Ref: Application AW/272/19/HH

My husband and I live at 49, Westminster Drive and have just seen the planning application for no 51 Westminster Drive, the middle of our block of three houses. It transpires that a previous owner of no 51 has slatted over the foul water inspection cover serving our property. This cover is just over the boundary line of our property and on to his. (no 51)

Drawing:
DESIGN PROPOSALS

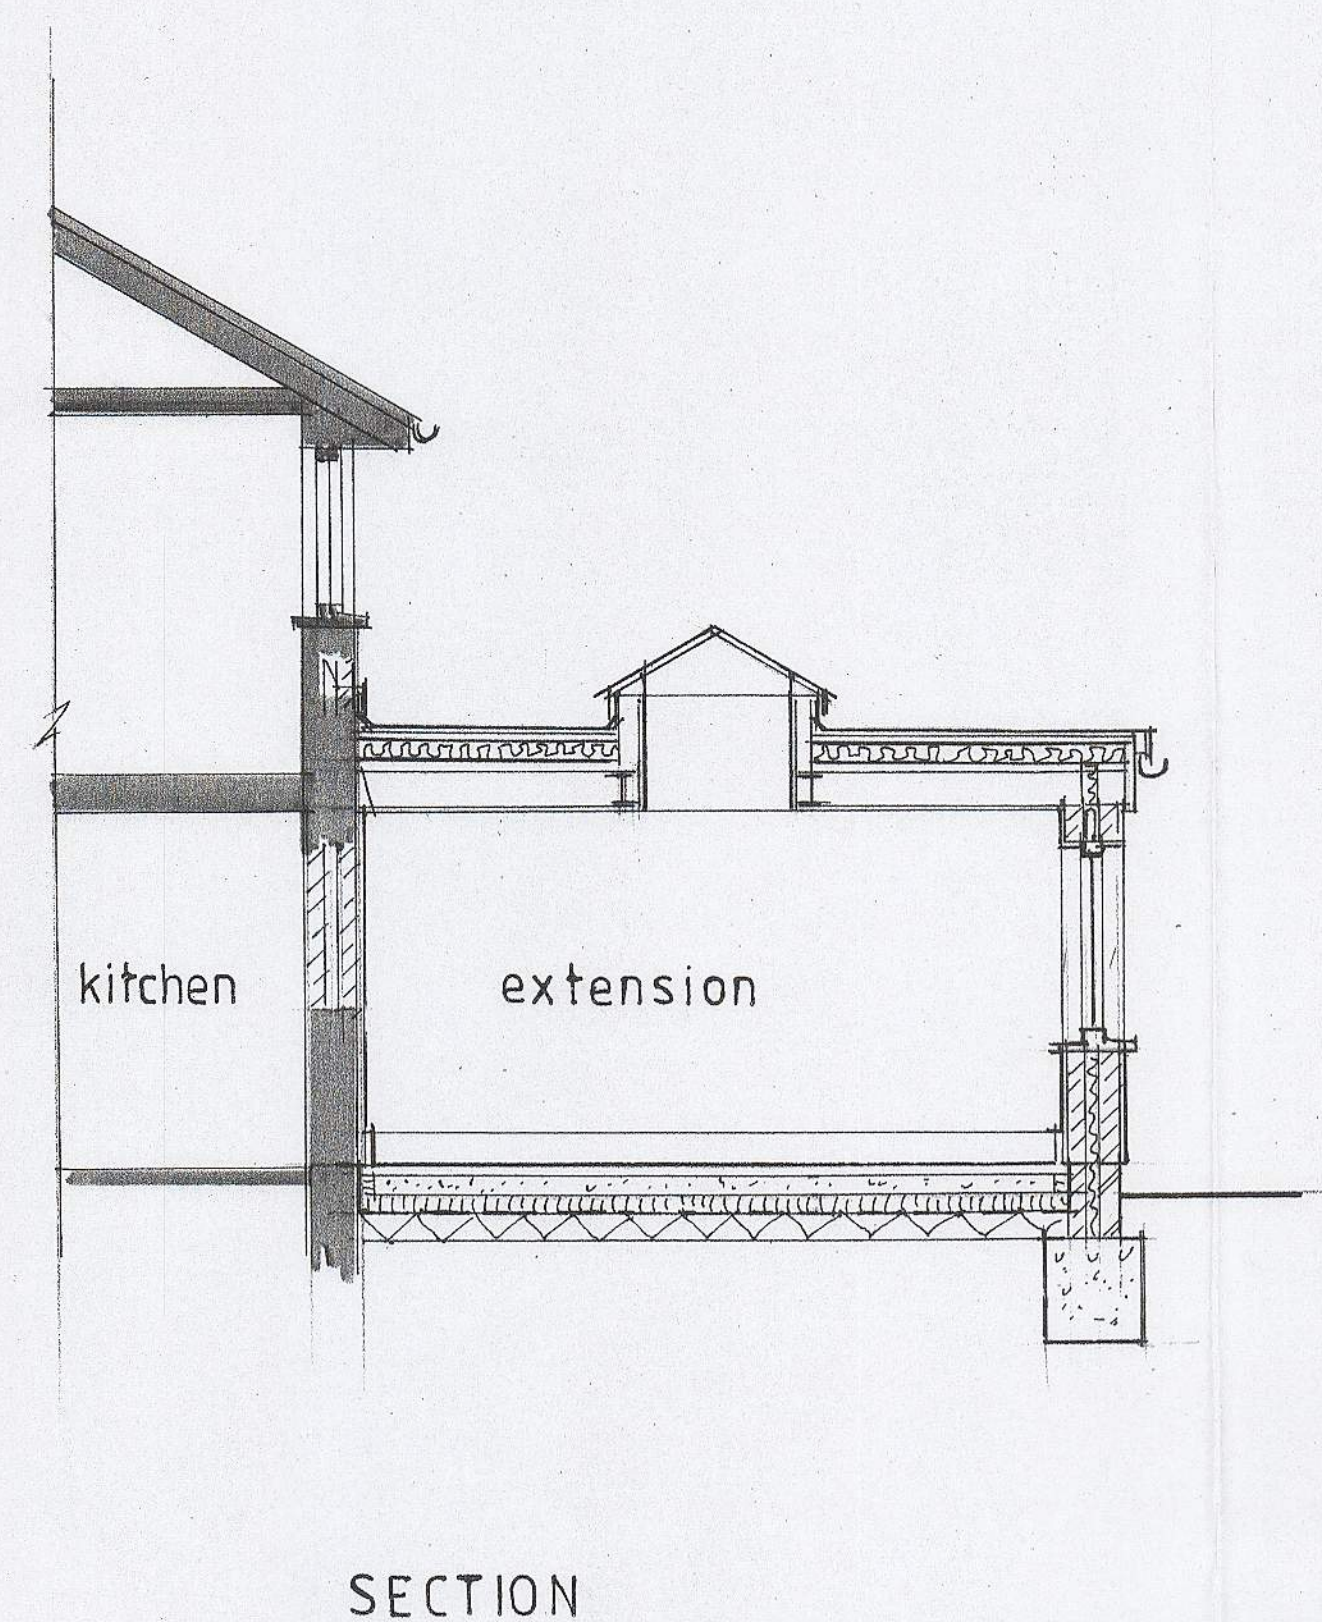
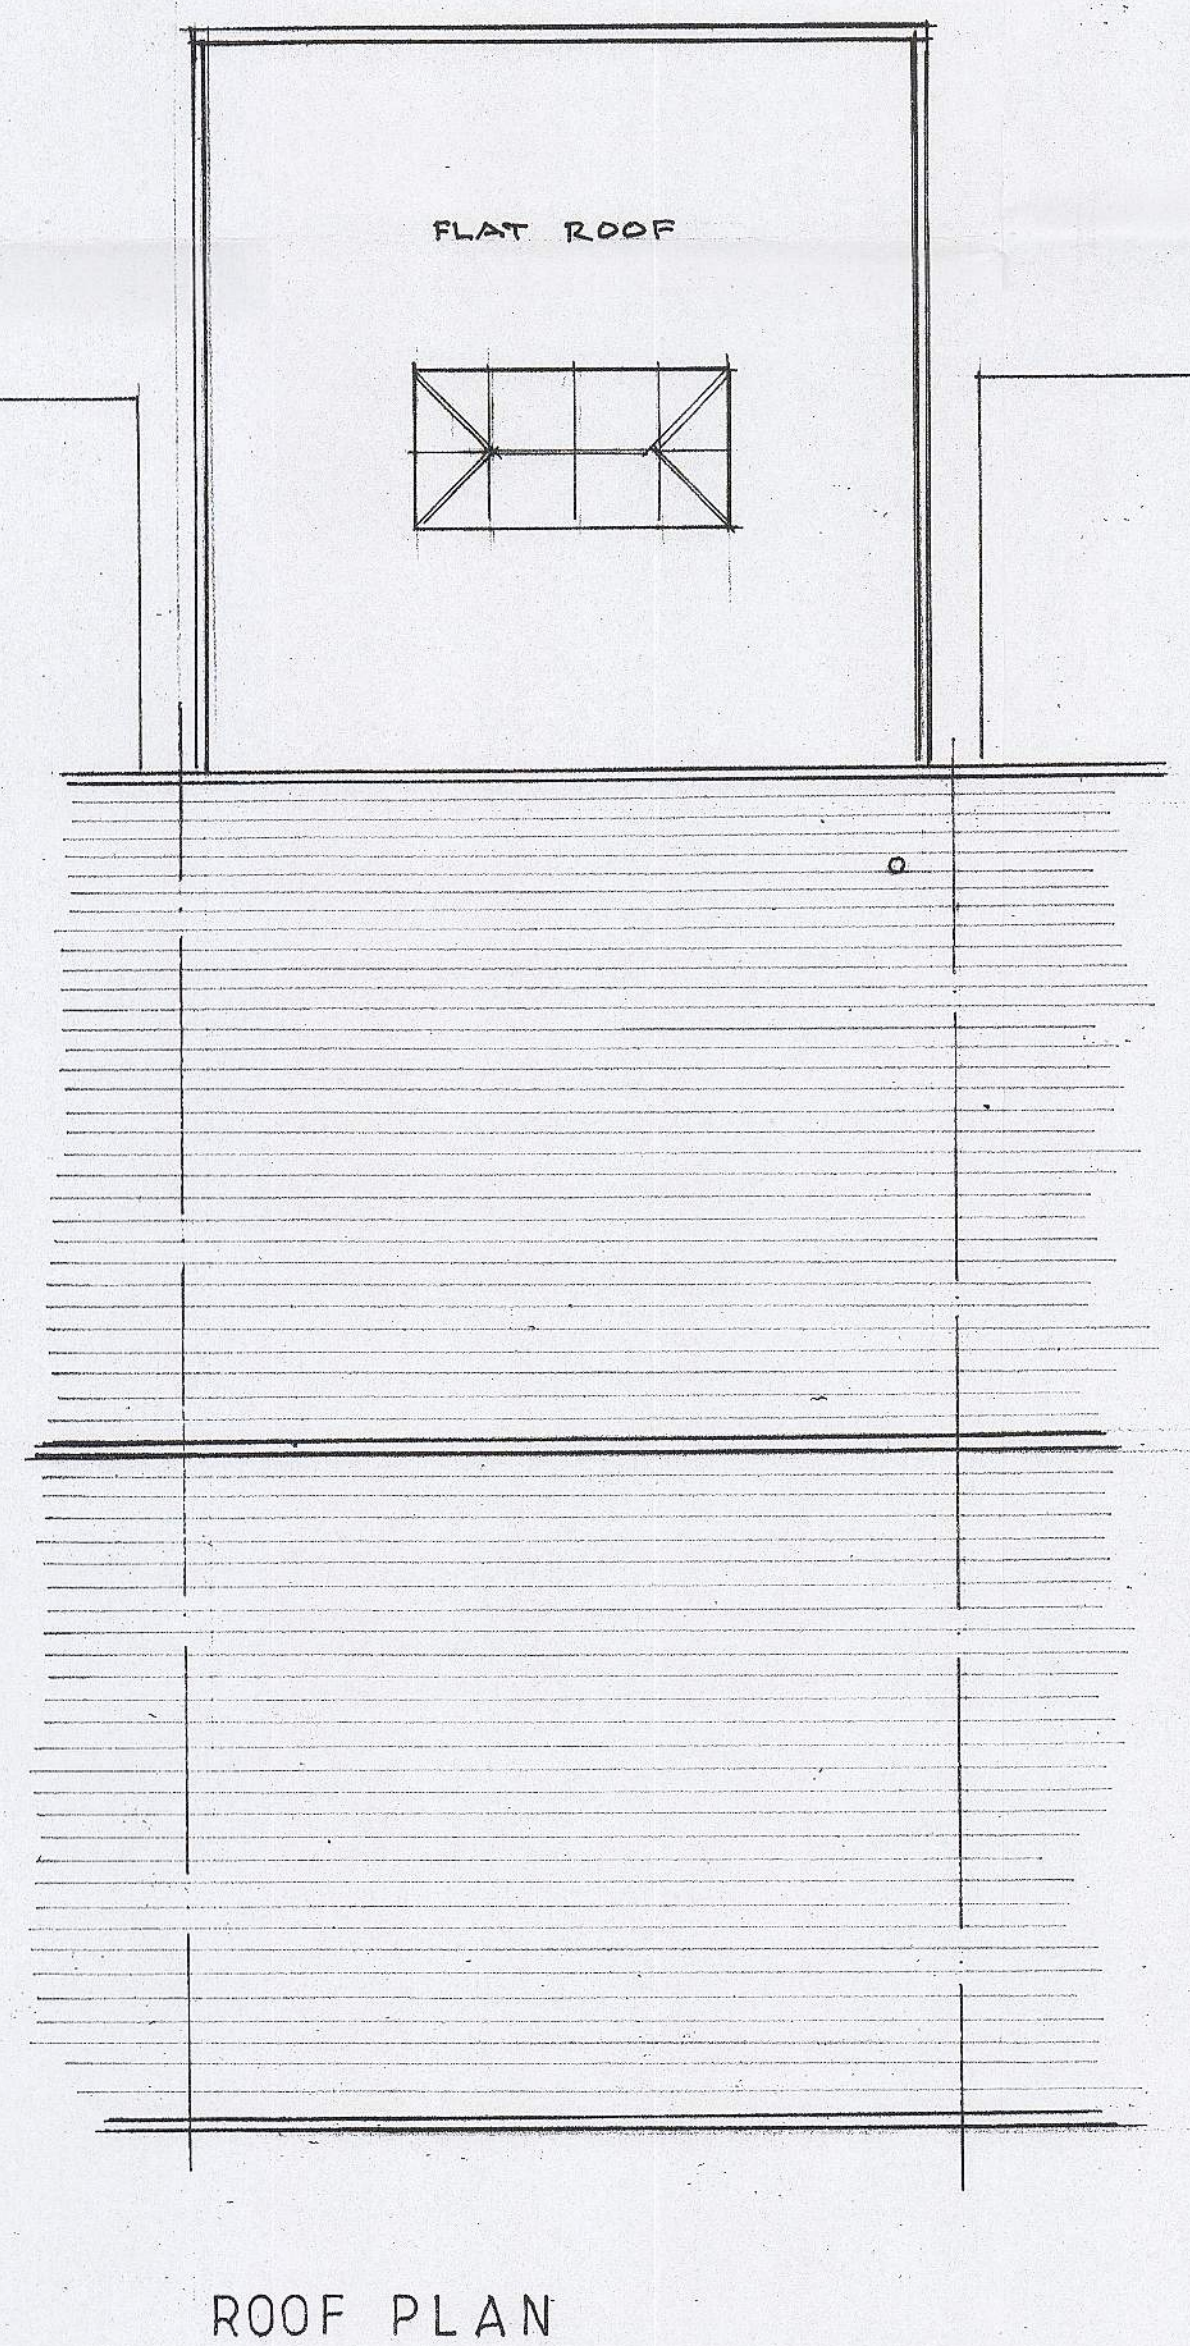
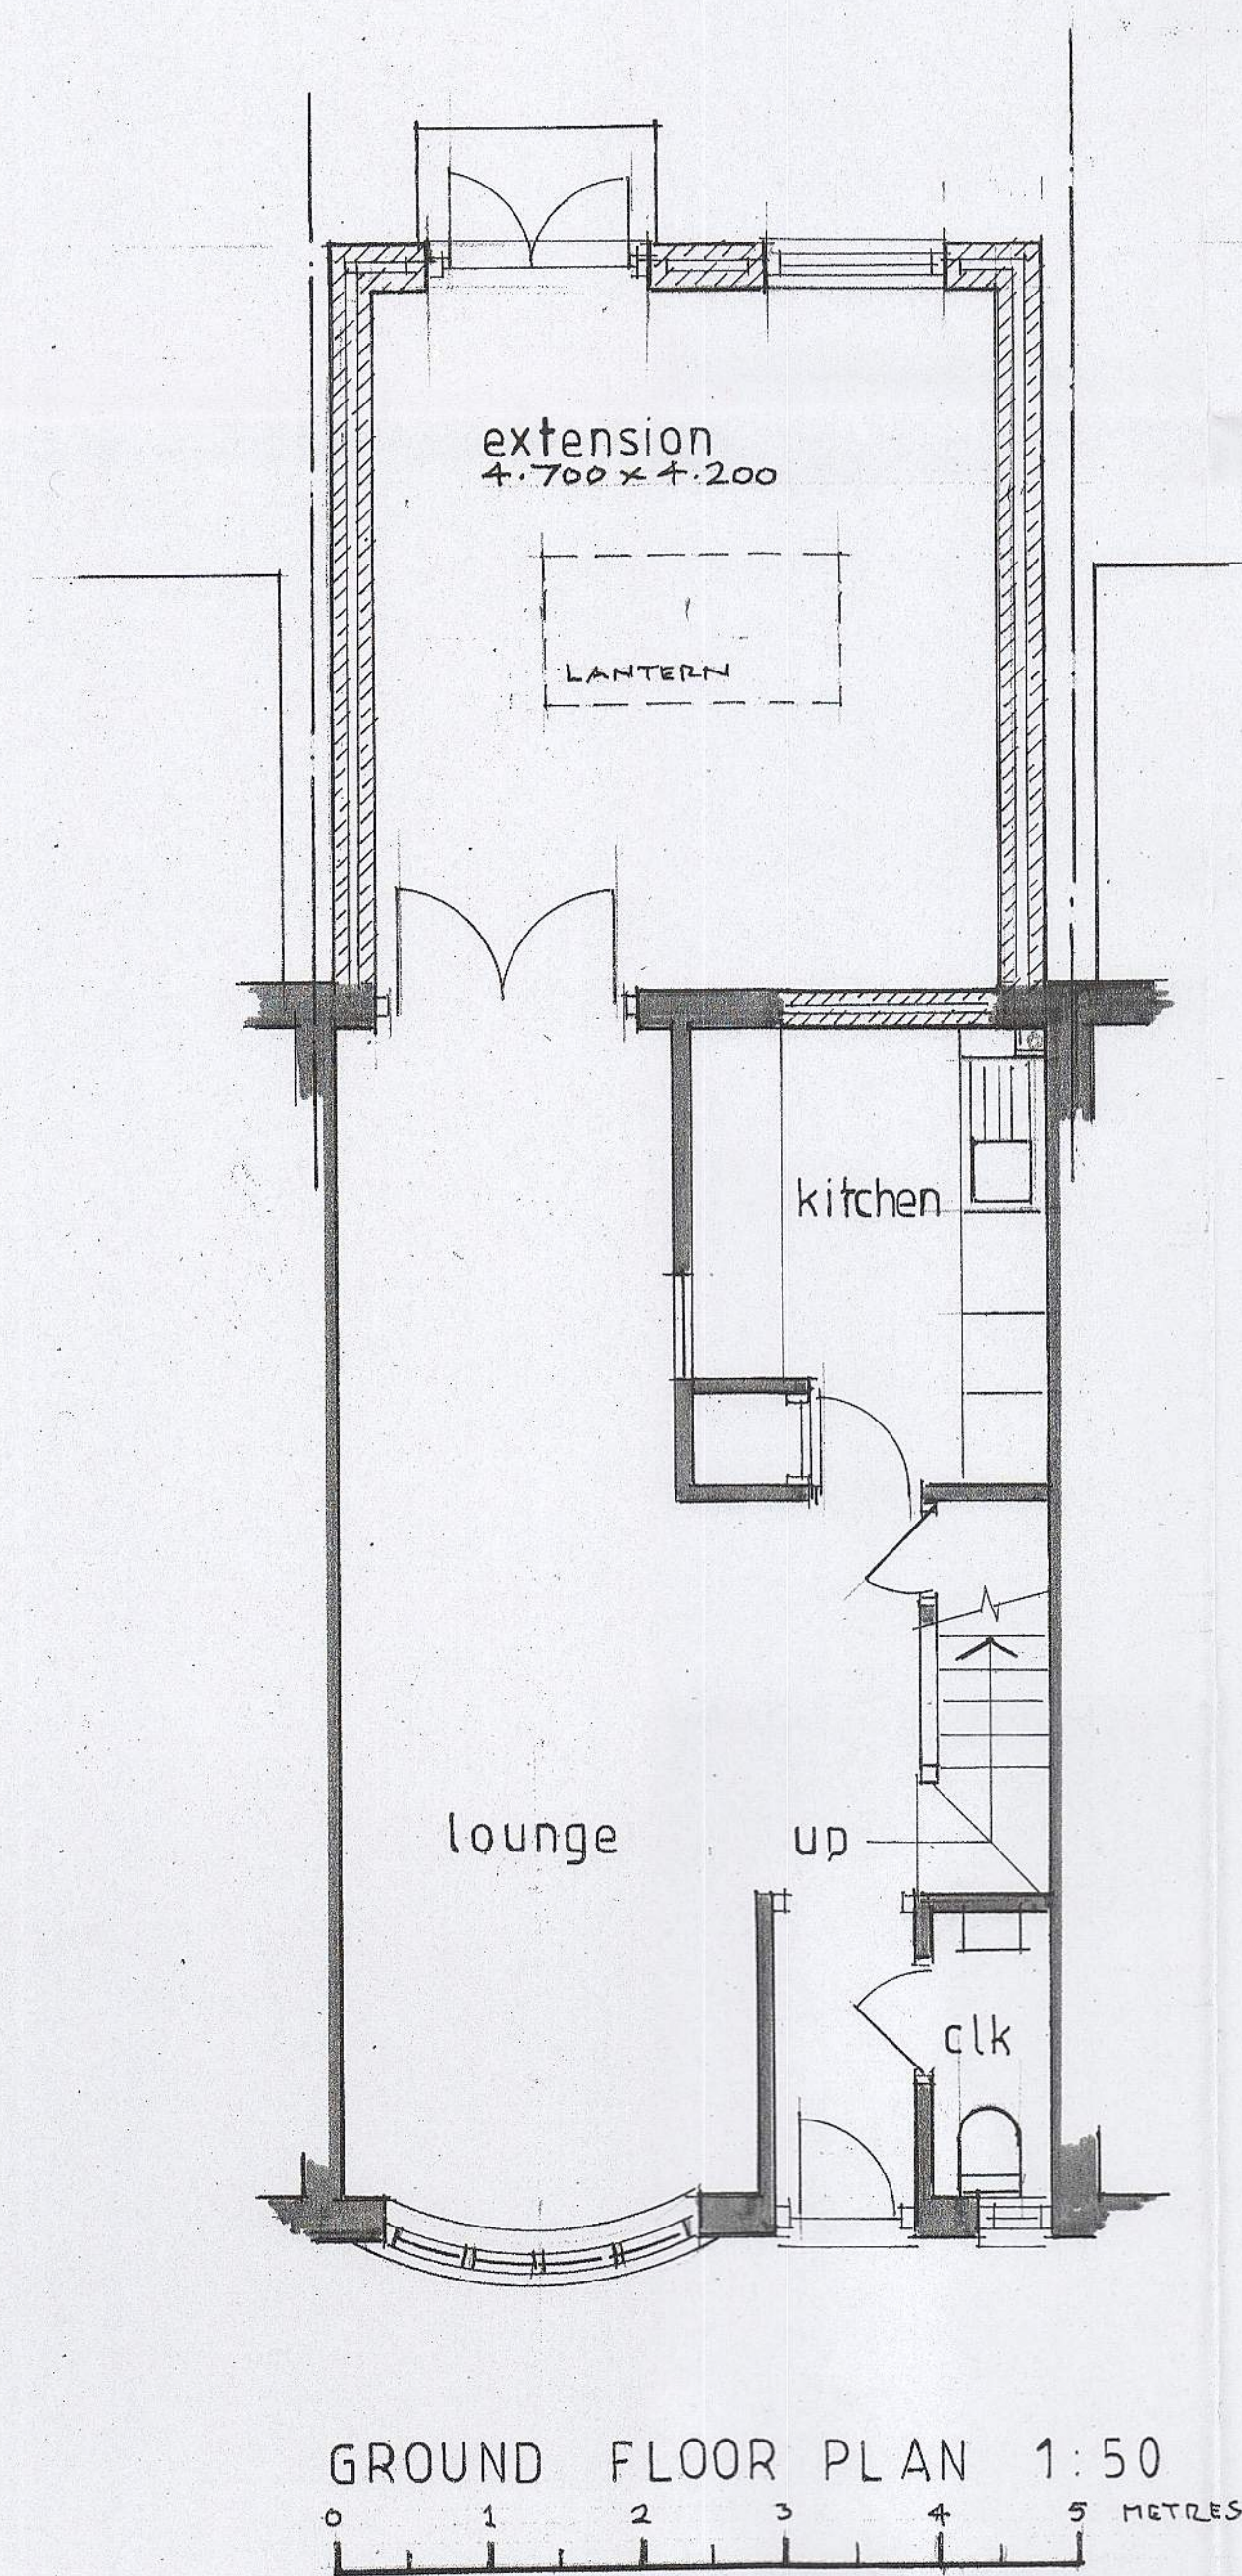
There is a foul water drain for all three adjoined properties which runs along under the ground about two and a half metres out from the back walls of no 51 and 53. We are also concerned that the foul water insp cover on no 53's ground has been covered over as well as there is an extension on the back of this house.

We are worried therefore that the architect and builders will not be aware of this foul water drain run (with relevant inspection covers) which runs close to the back of no's 51 + 53, as there is no visual evidence of this. We have lived here for over 40 years and know exactly where the inspection covers were situated before home improvements took place.

We have spoken to a retired building inspector and current architect and he informed us that because the drain run serves two or more properties Southern Water are responsible for it and will insist there is inspection access matching their records and will need to see plans of the proposed development in order to give consent to works above a drainage run. We understand that Southern Water have the power to refuse building works permission and that special measures need to be in place to protect the drain from damage or collapse.

Whilst we have no objections to the extension being built we would like all necessary precautions to be taken and the foul water inspection cover to be re-instated in an accessible place.
